PLANNING AMENDMENT

APPLICANT NAME AND ADDRESS MR M HASEEB SOVEREIGN PROPERTIES (ENGLAND) LTD 8 BLENHEIM COURT PEPPERCORN CLOSE PETERBOROUGH PE1 2DU Telephone:	AGENT NAME AND ADDRESS GOOD-DESIGN-ING LTD 11 SARACEN WAY NEWARK ROAD PETERBOROUGH PE1 5WS Telephone: 01733 569731
SITE ADDRESS DETAILS THE ROYAL BRITISH LEGION, CHAPEL STREET, CROWLAND, SPALDING PE6 0AR	
CURRENT APPLICATION NO: This amendment cannot be considered unless the relevant reference is stated.	H02-1272-21
Building Regulation reference relating to same development (if applicable)	N/A

DRAWING
Proposed Elevations
Scale 1:100 @ A1 size
drawing number
211276-09 REV A

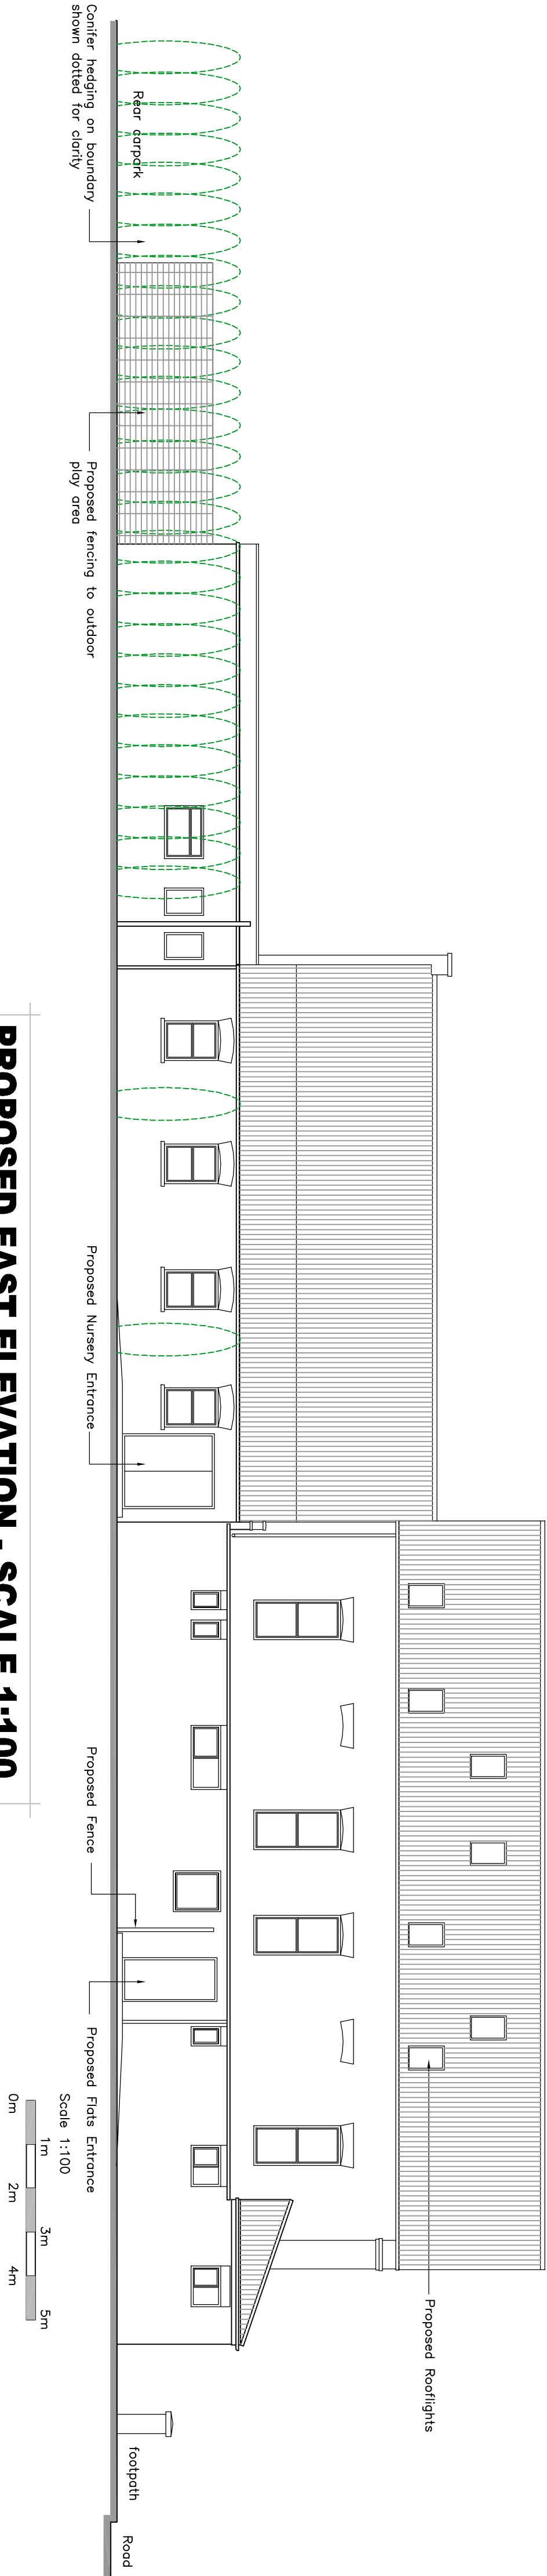
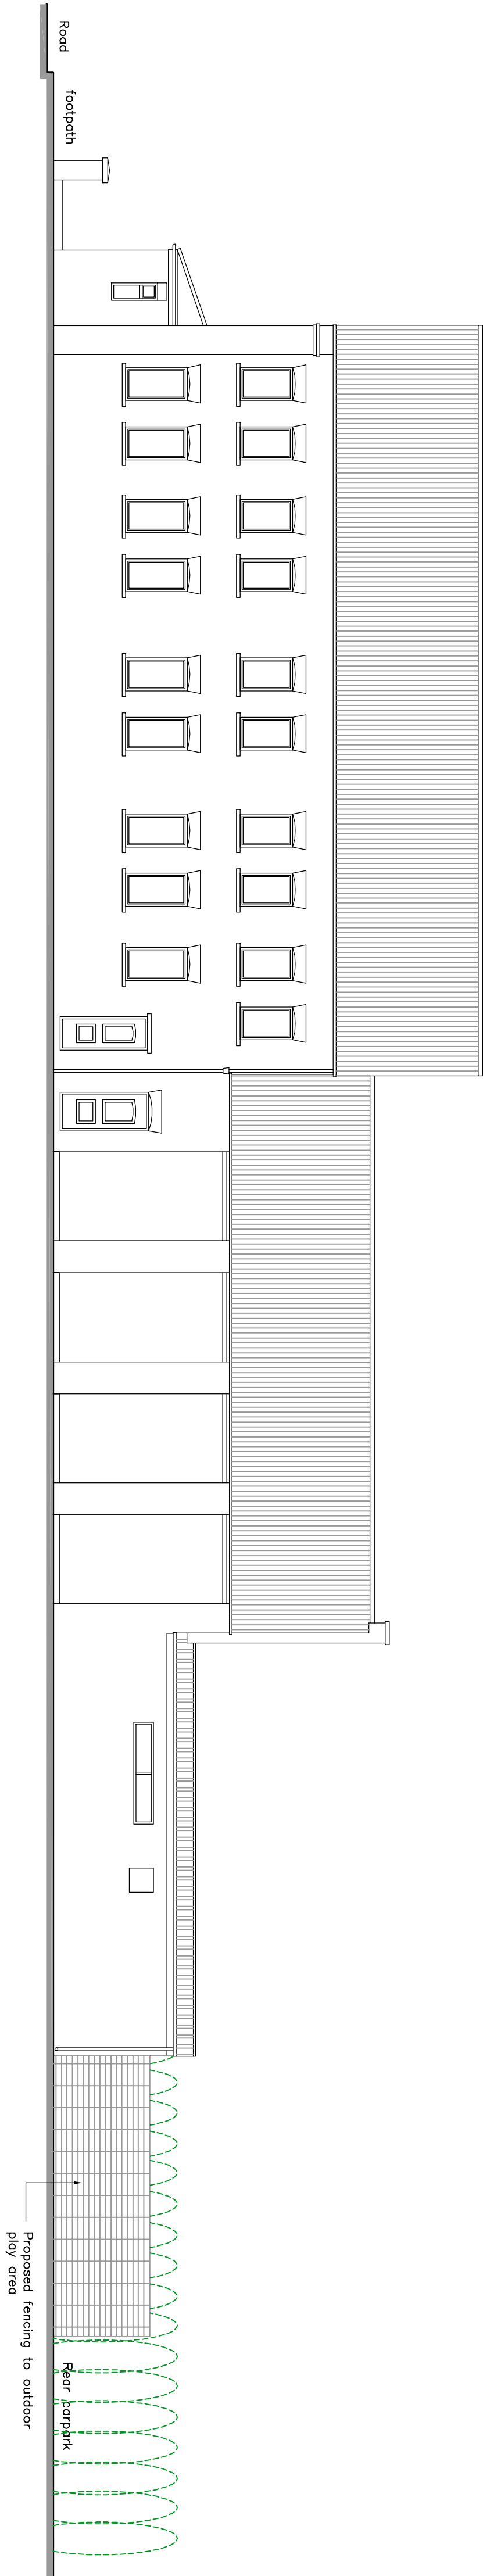
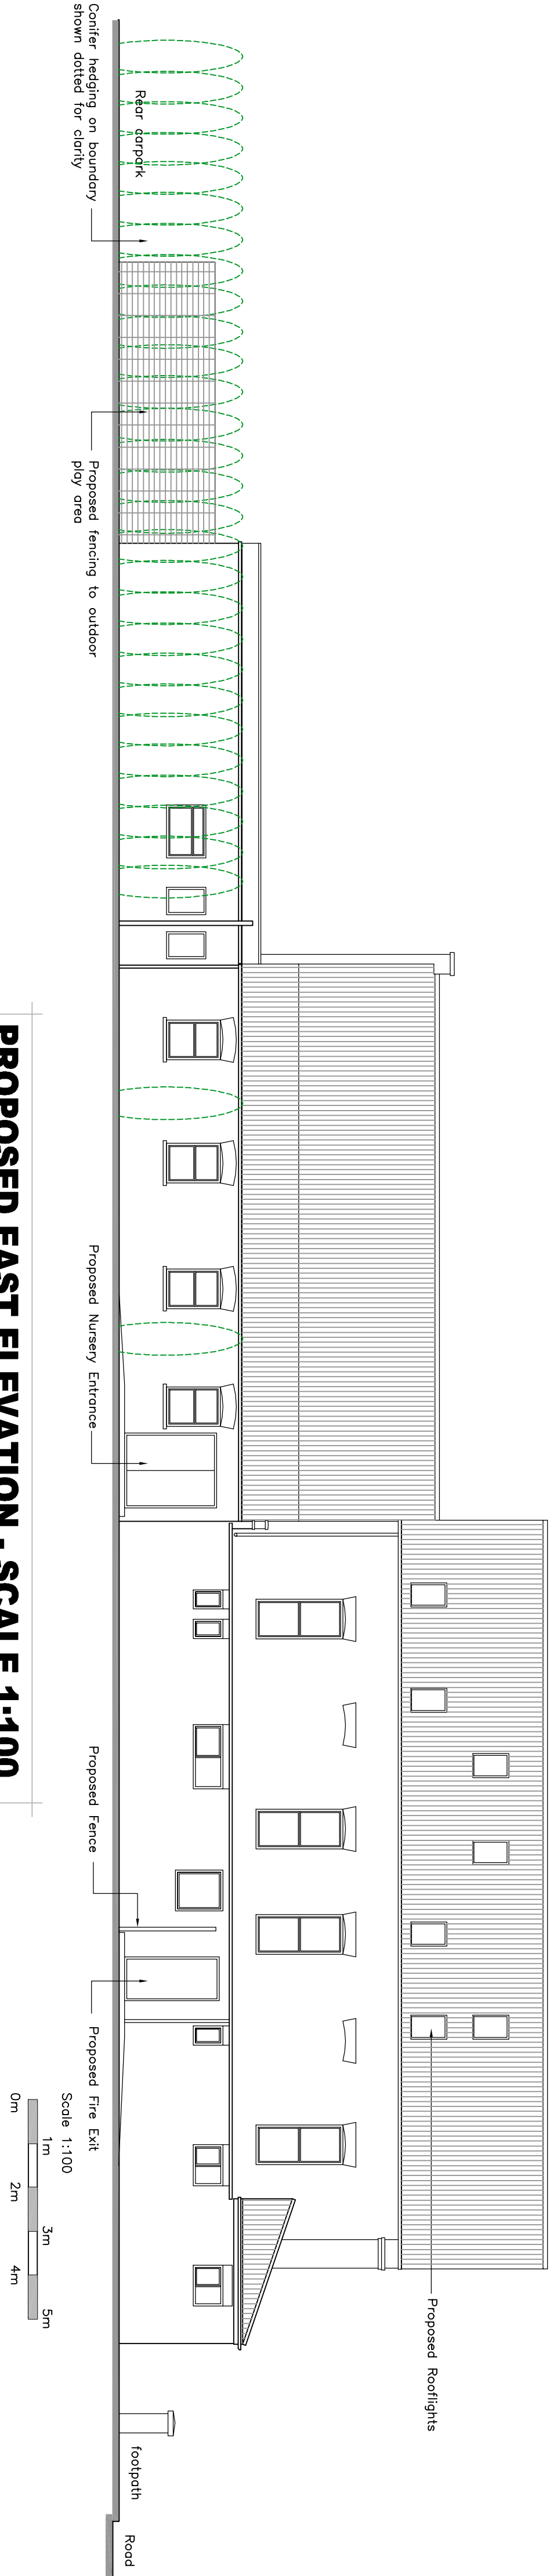
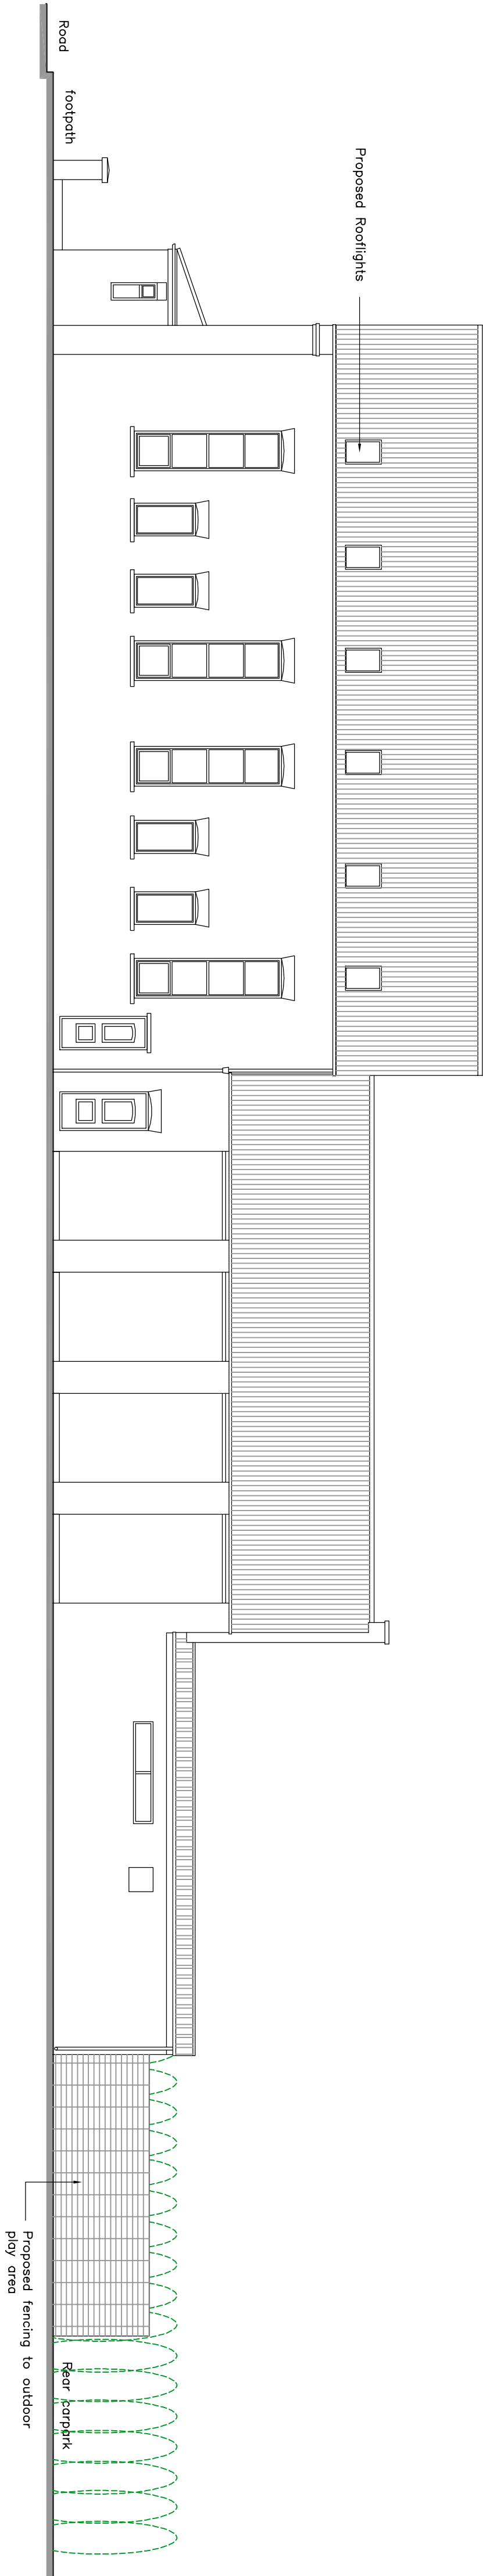
FULL DESCRIPTION OF DEVELOPMENT OF CURRENT APPLICATION THAT THIS AMENDMENT RELATES TO		
State details of amendments proposed. (Give a full detailed list of the changes; and also mark these clearly on the accompanying plans. Only the changes listed here will be considered)	CHANGES TO FIRST FLOOR AMENDED, EXTERNAL WINDOWS REMOVED, ROOFLIGHTS ADDED. TO NEW DRAWINGS 211276-04REV A, -05REV A, -07REV A -09REV A	
State drawing numbers of the current submission	211276-01, -02, 03, -04, -05, -06, -07, -08, -09	
Has this amendment been requested by the Council? (If so, state Officer dealing with the application)	YES/NO	NO
Describe any part of the original development which is excluded by virtue of the amendment, and state any alteration to plot numbers	CHANGES TO FIRST FLOOR USE, EXTERNAL WINDOWS REMOVED, ROOFLIGHTS ADDED	
Has a similar amendment been submitted under Building Regulations? (If so, state Building Control Surveyor dealing with application)	YES/NO	NO
